Planning Inspectorate

Reference your letter EN020027 dated 5 June 2026 and the Applicants reply at Document: 8.26 Response to Rule 17 Letter received 5th June 2026.

3.1.1 ‘At the Accompanied Site Inspection on Wednesday 27 May 2026 the ExA noted the proximity of cottages 70, 71 and High Hopes, Flordon Road (postal address Norwich Road, Flordon, NR15 1RU) to the Order Limits and their relationship with 72 and 73 Flordon Hall Cottages NR15 1RT. These properties have not been assessed in the Residential Visual Amenity Assessment [REP4-148]. The ExA requests an assessment of these properties.

Representation – Vision/Intrusion

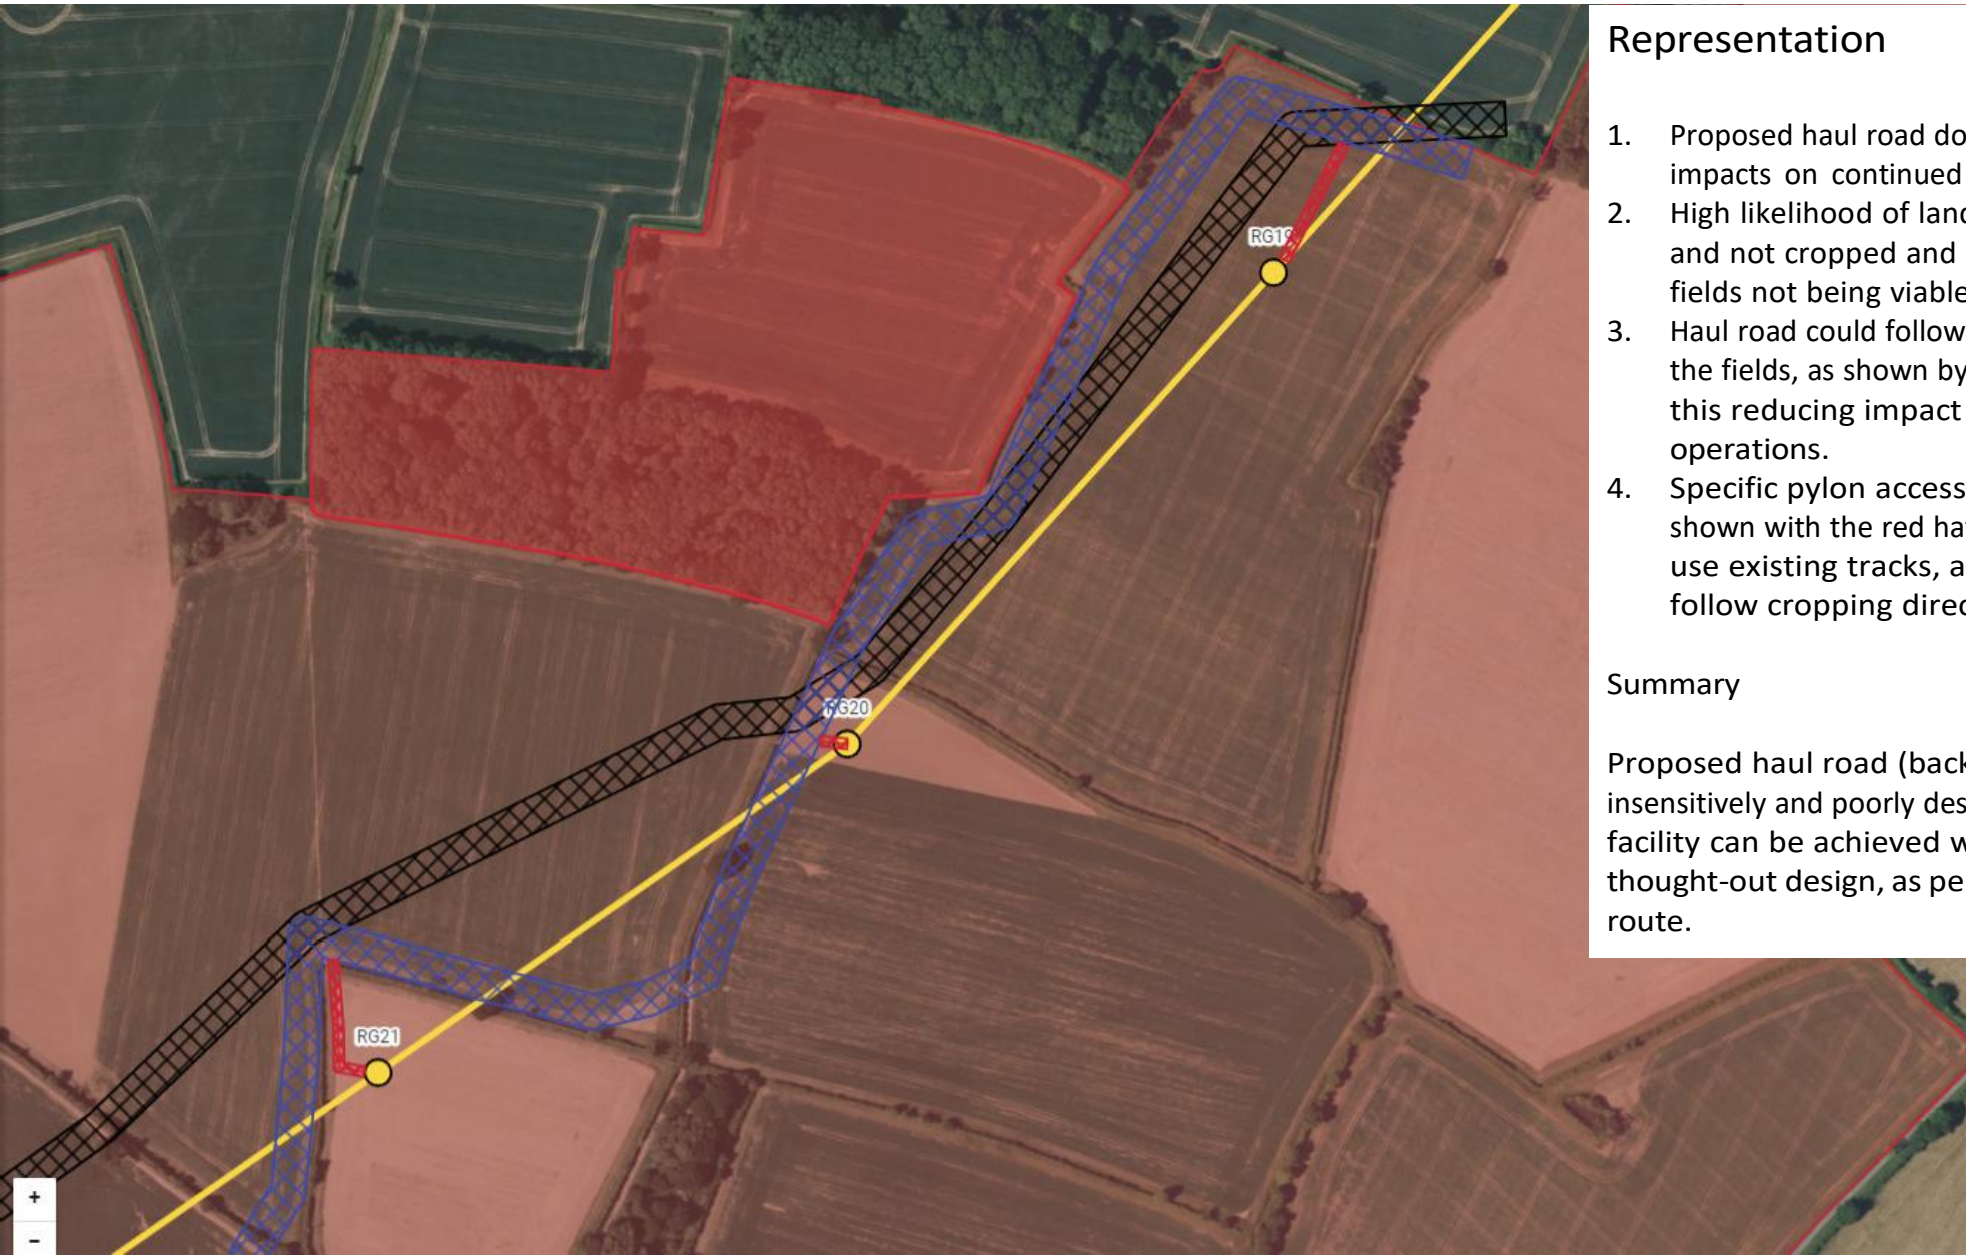
pictorial submissions. The applicant has not answered the question and failed to mention the properties No 72 and 73 Flordon Road, NR15 1RT in the response. Both these houses are within 120 and 130 meters of pylon RG 21 respectively and so would become subject to the RVAA as determined by the Applicants own admission in paragraph 4.7 of LI TGN 2/19 which states that ‘when assessing effects of overhead transmissions lines, generally, only those properties within 100 – 150 metres of the finalised route are potentially considered for inclusion in a RVAA’. The RVAT is defined in paragraph 2.1 of LI TGN 2/19 as the point ‘at which the visual amenity of a residential property is changed and adversely affected to the extent that it may become a matter of Residential Amenity and which, if such is the case, competent, appropriately experienced planners will weigh this effect in their planning balance’. To compound the problem, it has only recently come to light that trees and hedges in the curtilage of No 72 Flordon Rd will be removed to facilitate the undergrounding of electrical cables that are currently in place. The kitchen window and a bedroom window of property no 72 Flordon Road look directly towards pylon RG 21 and the removal of the vegetation will have a dramatic effect. Paragraph 13.2.26 of the RVAA [REP4-148] states that the RVAT is judged by considering whether the Project, for example blocks the only available view from a property, is overwhelming in views in all directions from the property, is unpleasantly encroaching and / or is inescapably dominant from the property. No 72 Flordon Road in particular will have pylons RG 21 and RG 22 clearly and inescapably dominating all views from the property.

In respect of houses at 70 and 71 Flordon Road and the House, High Hopes, both the measurement distances recorded and the Viewpoint pictures are wide of the mark. Furthermore, if the maps presented are accurate and RG 22 is at the point marked, then the measurements they claim to the curtilage are inaccurate. When measured accurately on the ground they are wrong by at least 15 meters, this begs the question, how many other measurements are inaccurate? The viewpoint pictures are interesting. 3.2.9 states that the visualisations are not verified views (*as data from their locations has not been collected in person*). For once it seems that I must agree with the Applicant; this must be one of the most accurate statements they have made. It is very evident that the illustrations bear no similarity to reality and that whomever produced them, had never set foot on that area of the farm. We are not sure whose fields the visualisations are depicting but they have no resemblance to ours, even taking into account that they purport to show the hedges and trees in winter.

To clarify and to eliminate any doubt, High Hopes has a plain 5-foot-high wooden panel fence surrounding the property on all sides. It has two vehicle gateways, (in and out), on the west side leading onto Flordon Road. There are no trees, hedges of vegetation that would obscure the view of Pylon RG 22 from the property. You can currently see 9 existing pylons for High Hopes Garden and in excess of 15 from the east and south facing bedroom windows. There will also be a clear view of pylon RG 23 from the south and west facing bedroom windows. The Applicant also states the following in respect of cumulative development within the area:
